From: Maria Tomalova <Maria.Tomalova@arun.gov.uk>
Sent: 02 November 2020 11:16
To: Planning.Responses <Planning.Responses@arun.gov.uk>
Subject: FW: AL/68/20/DOC

Subject: AL/68/20/DOC

We have received the comments from Drainage Engineers with regards to the discharge of conditions 10 and 11, subject to the above application:

| DRAWING TITLE<br>DRAINAGE LAYOUT          |            |          |            |             |     |

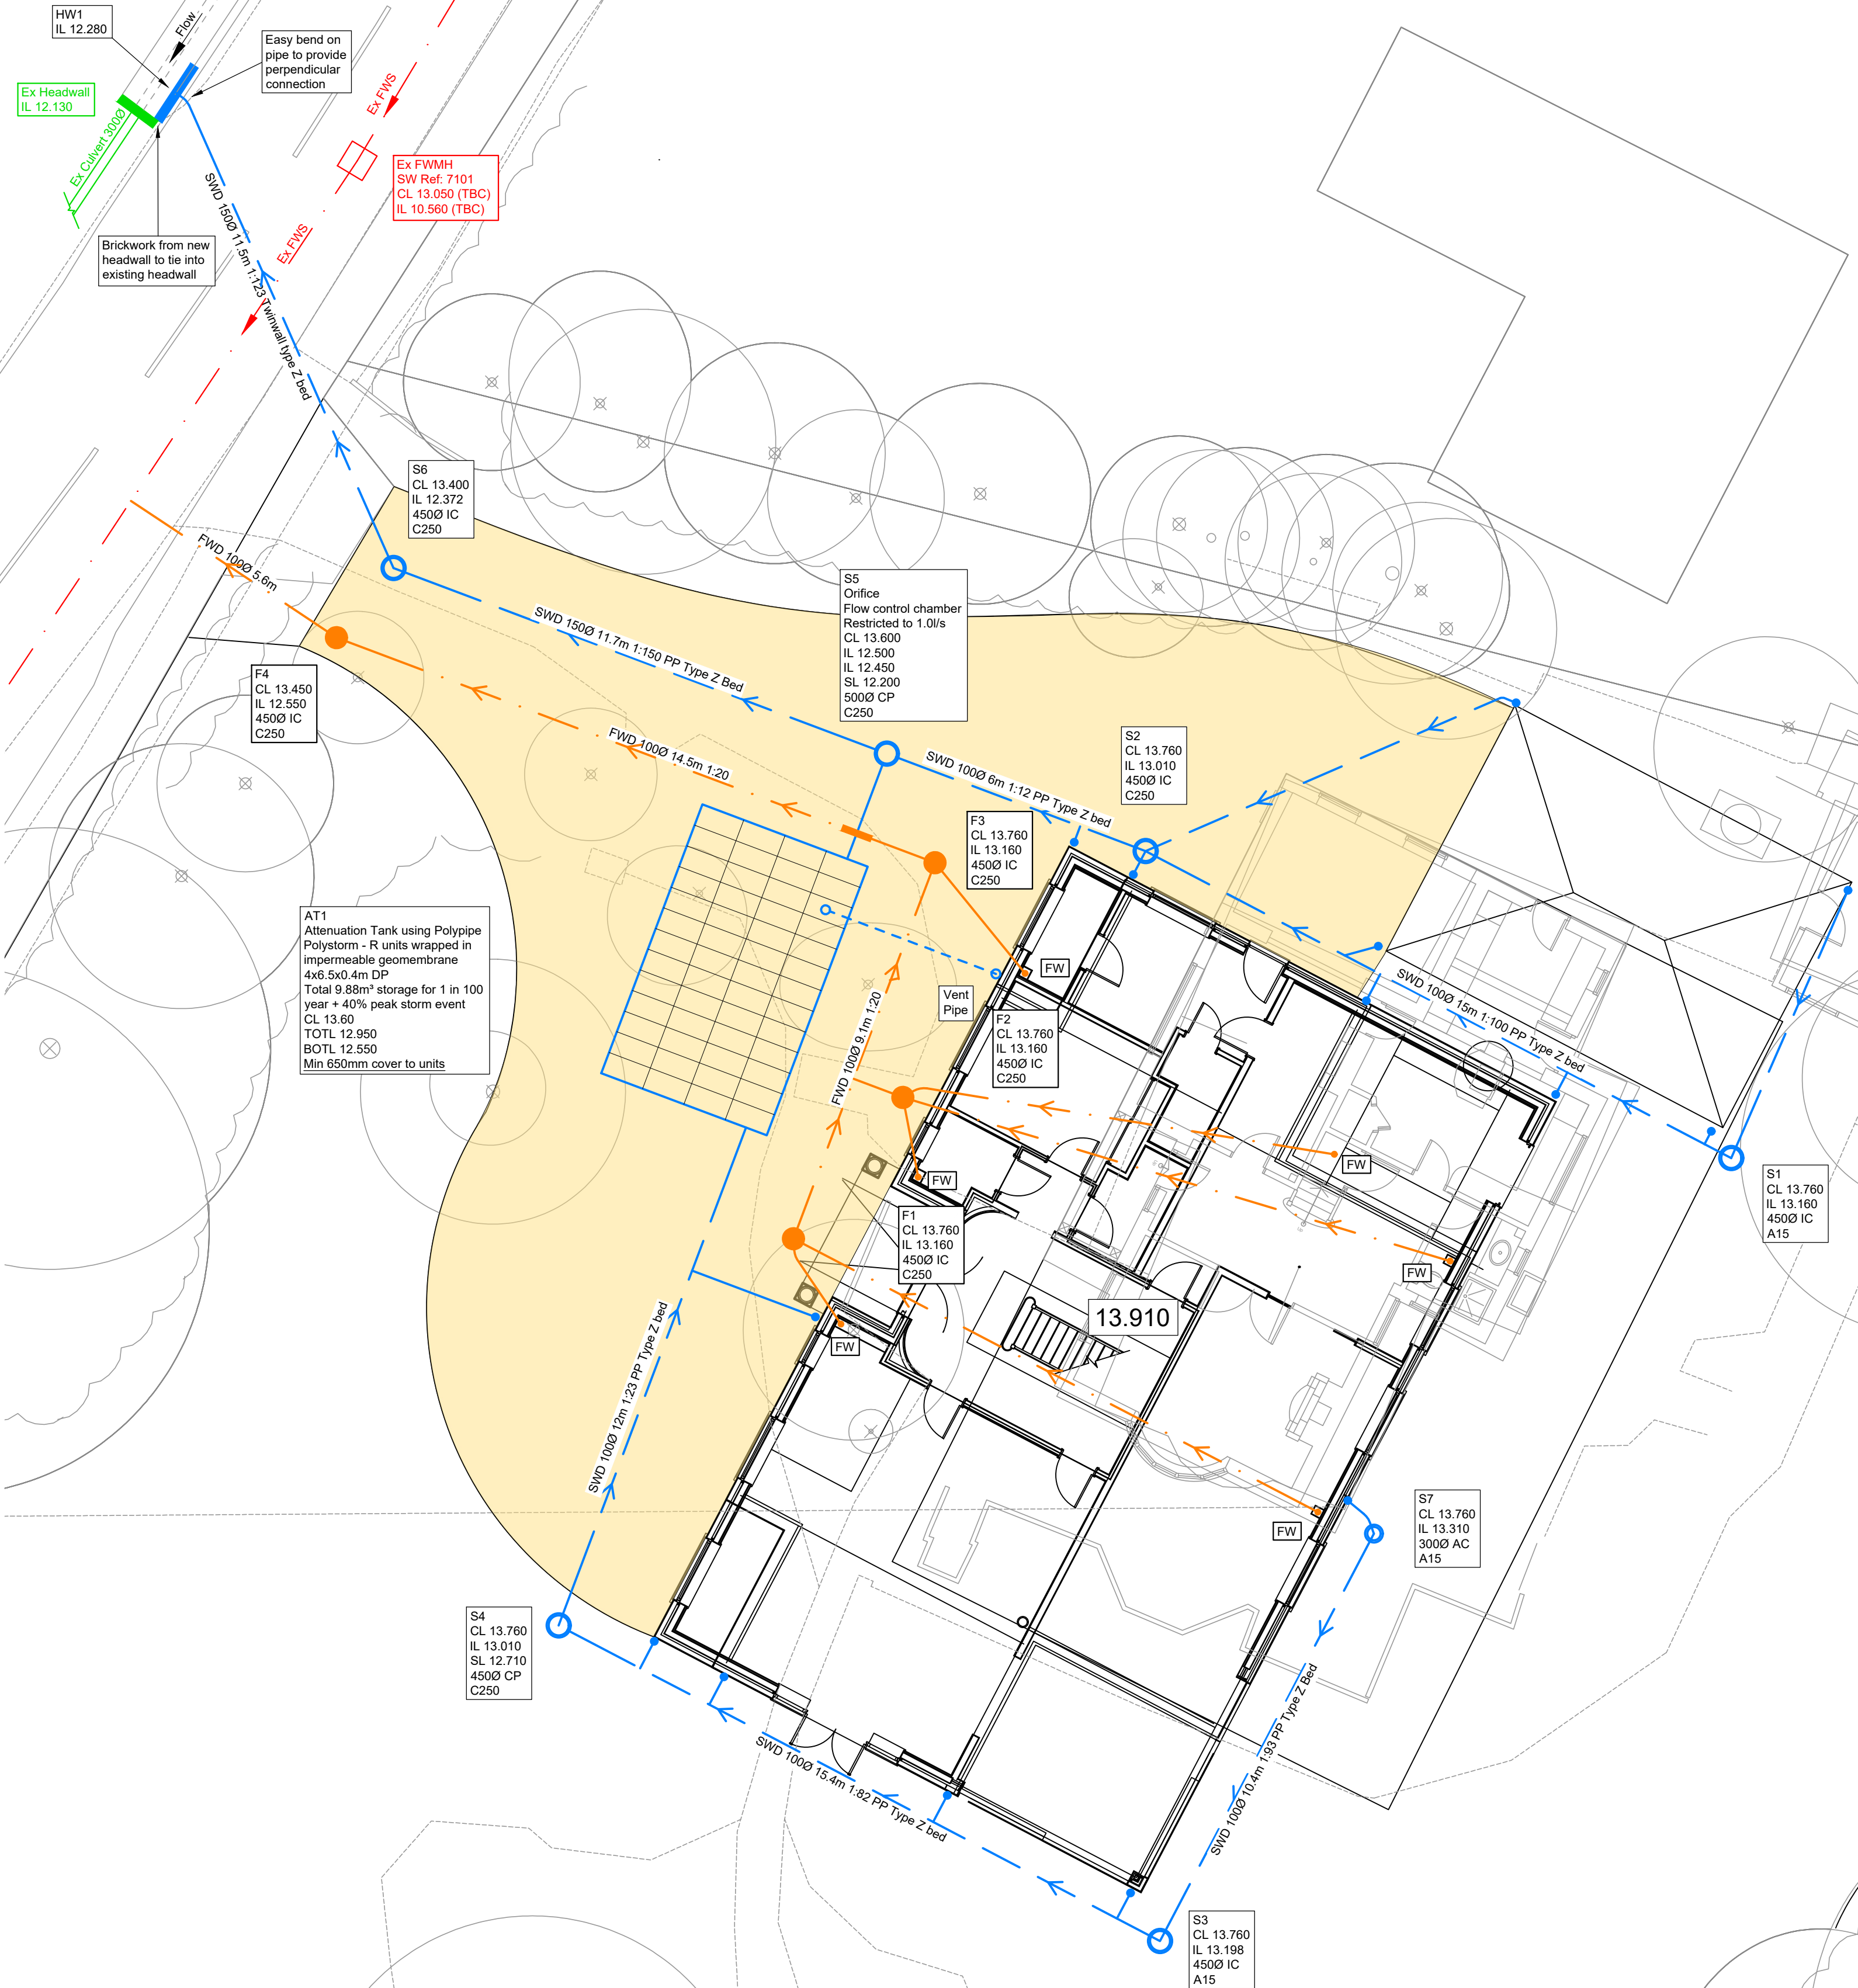
'We recommend this application to discharge conditions 10 and 11 is refused. Until it is demonstrated that the site can be drained to an acceptable discharge location it is not possible to approve drainage proposals under this discharge of conditions application. Any alterations to discharge location, or point of connection, will impact upon the wider proposed drainage scheme. It is essential to know the discharge location to be able to assess whether proposals are adequate and will not increase flood risk elsewhere.

Just to inform you we have submitted our revised information to Paul Cann to approve which we're confident will happen with this latest design.
